Planning & Infrastructure

Our ref.: MP 10_0027

Subject: Exhibition of Environmental Assessment for Site 3 Mixed Use Development at Australia Avenue, Sydney Olympic Park (MP 10_0027)

Site 3
Sydney Olympic Park
Elevation
North & South

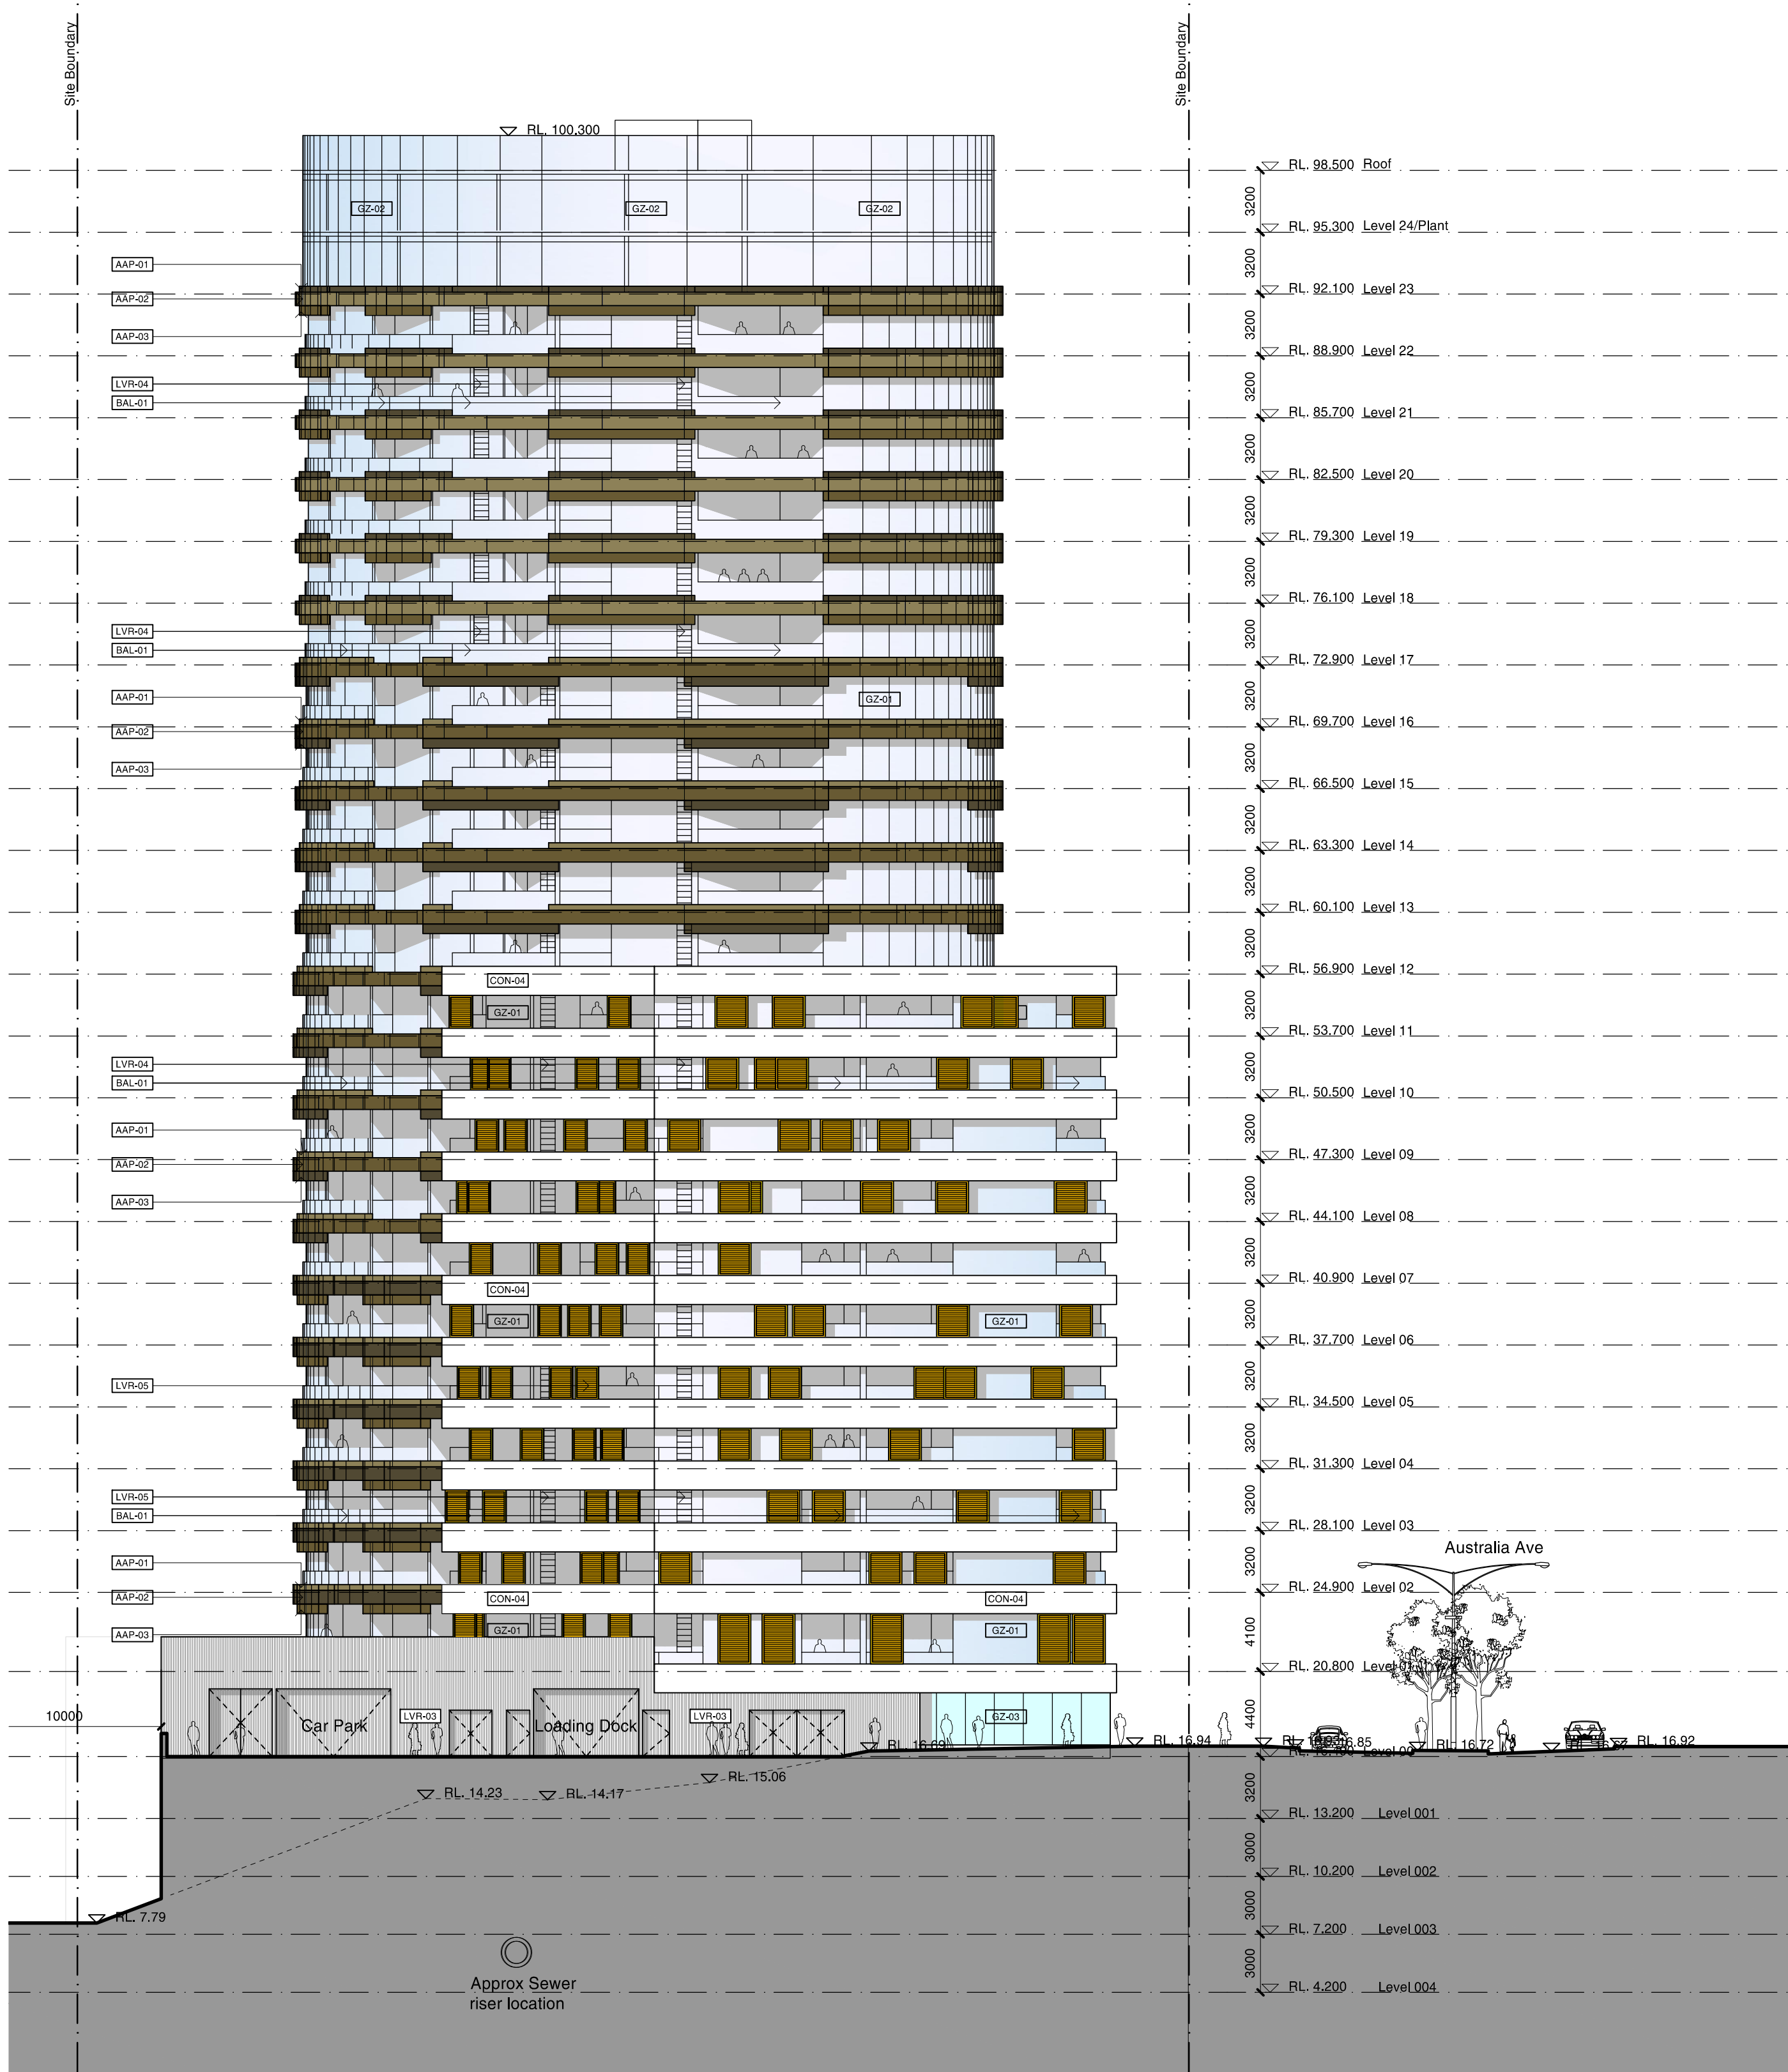
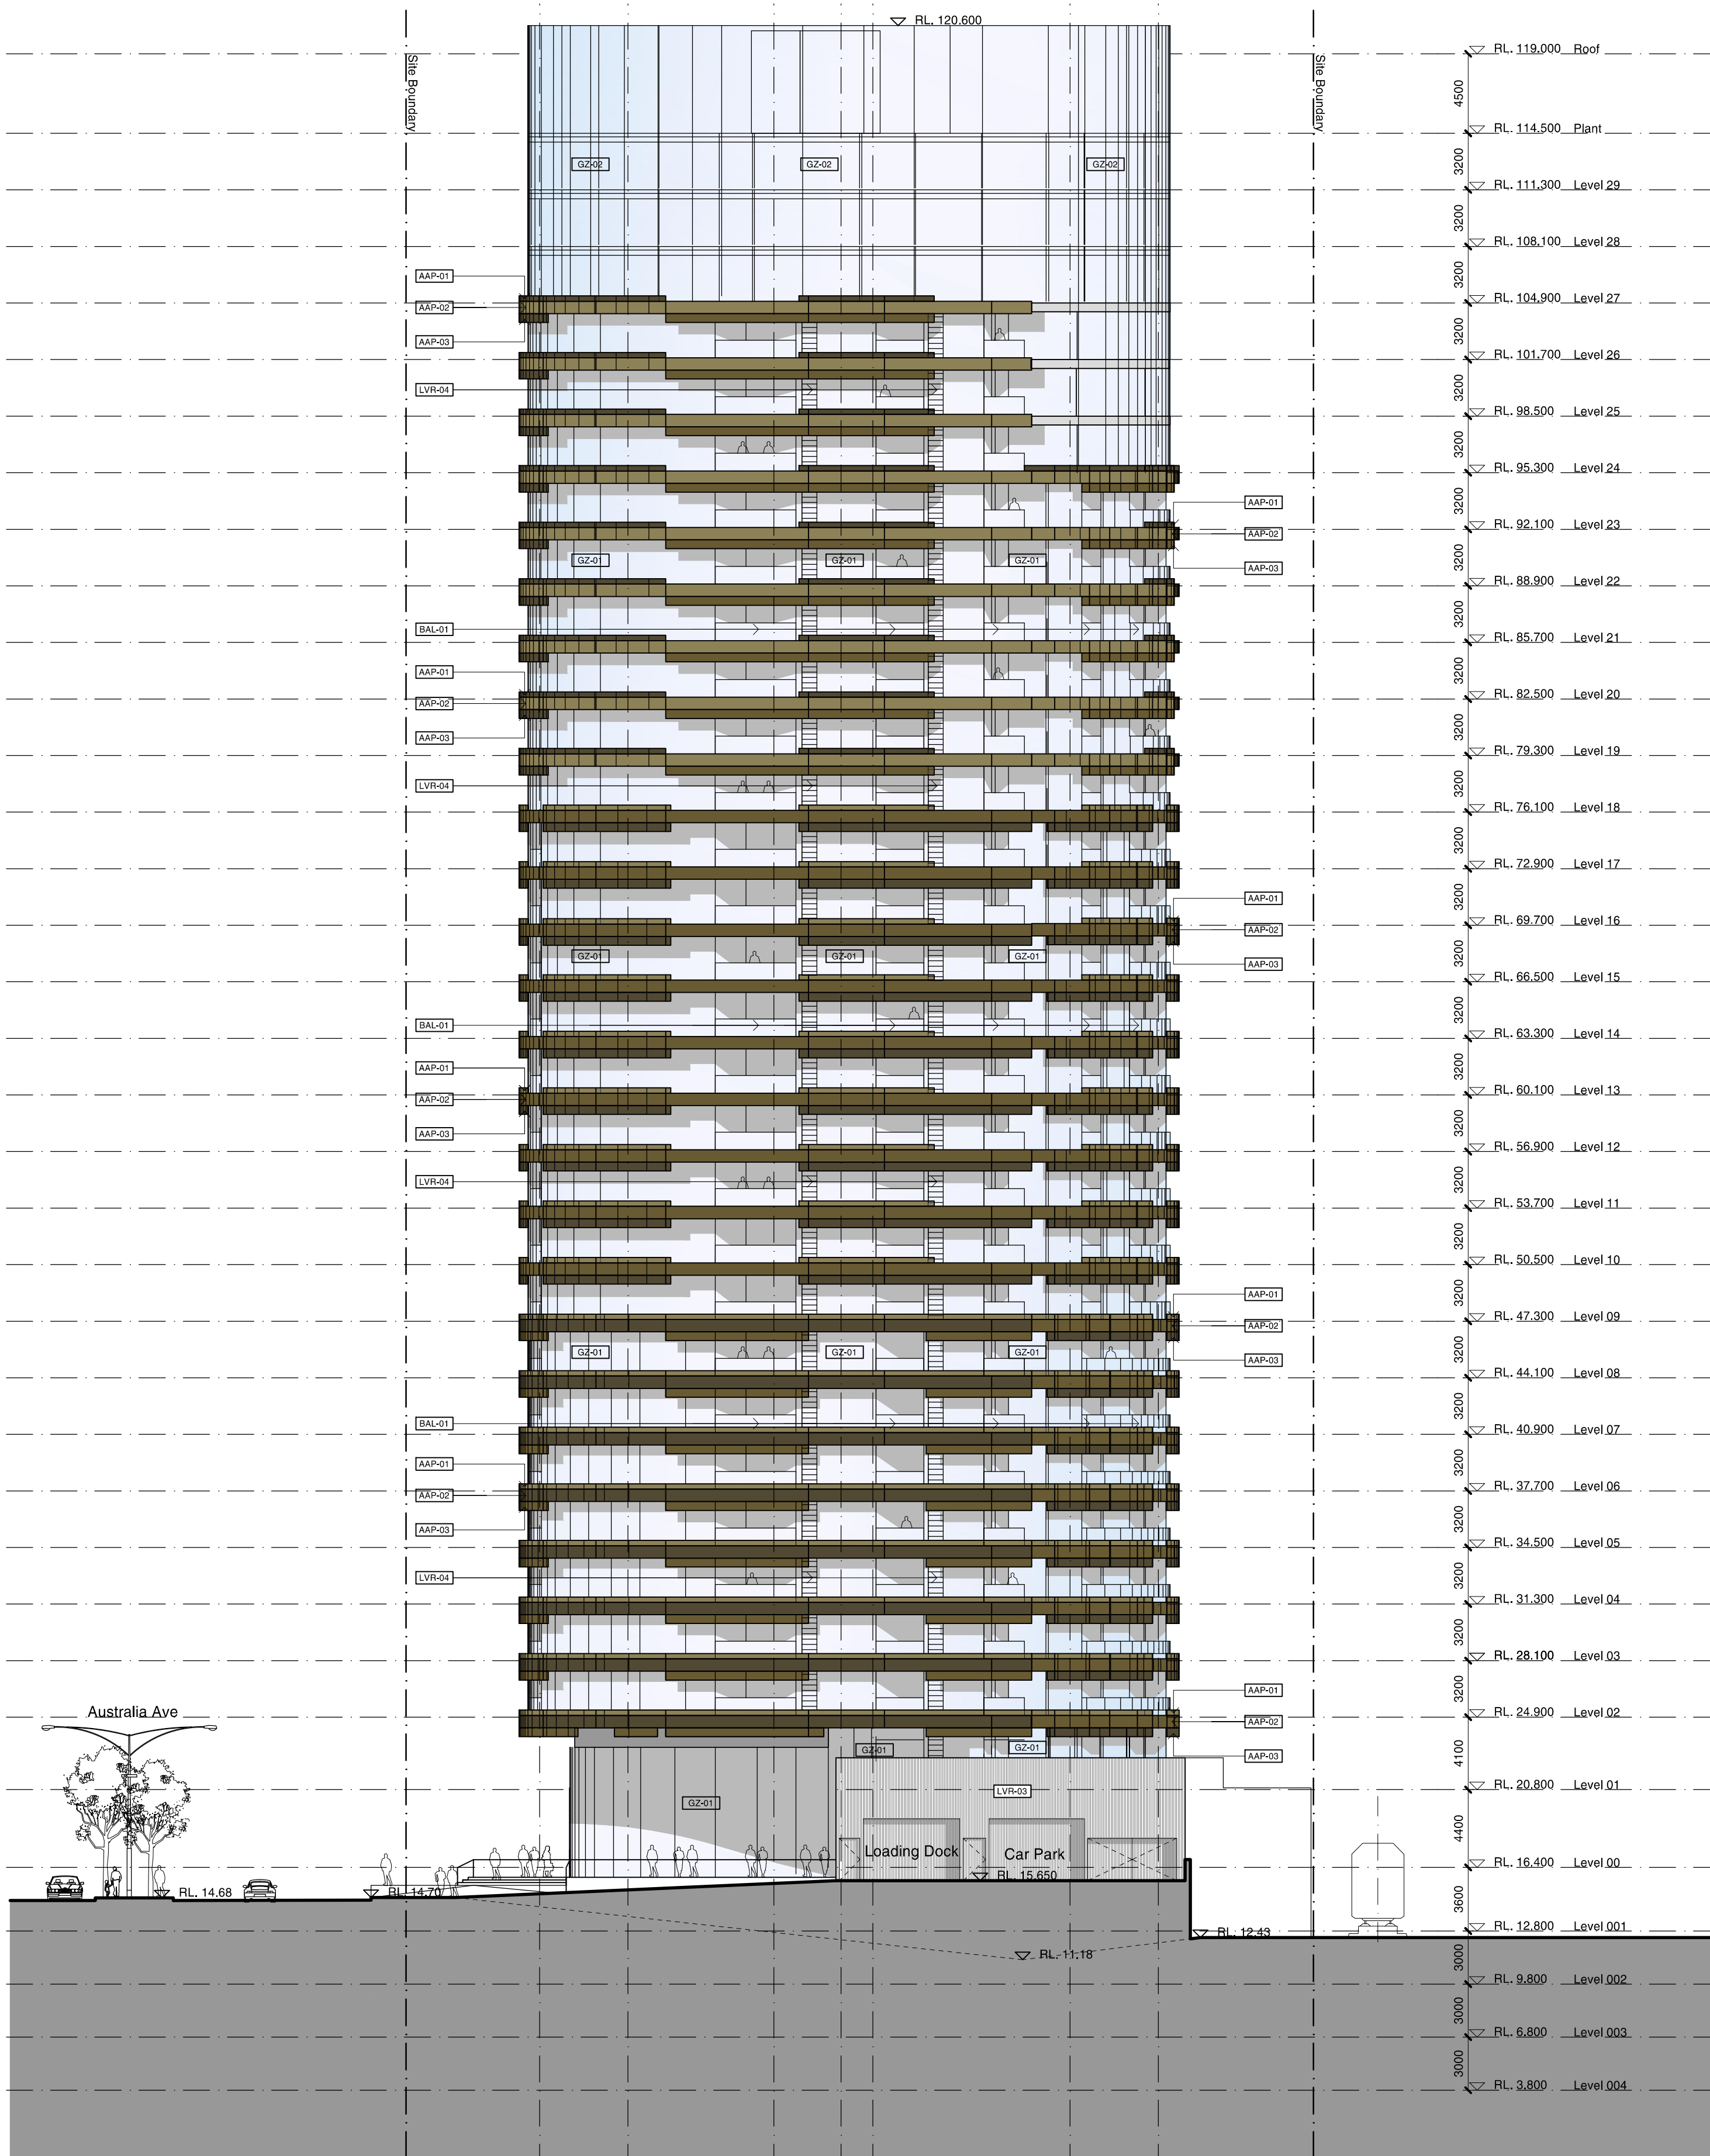
- clarification regarding the maximum height of Towers 1 and 2 above existing natural ground level;
- a rooftop services zone for both towers that complies with Sydney Olympic Master Plan 2030, height and setback requirements, or provide justification for any non-compliance;
- clarification regarding compliance with tower separation requirements in the Sydney Olympic Master Plan 2030, or provide justification for any non-compliance;
- clarification regarding the percentage of units that would receive three hours of solar access and justification for any non-compliance with the relevant requirements;
- details of the retail and commercial car parking arrangements and servicing arrangements; and
- a final BASIX certificate.
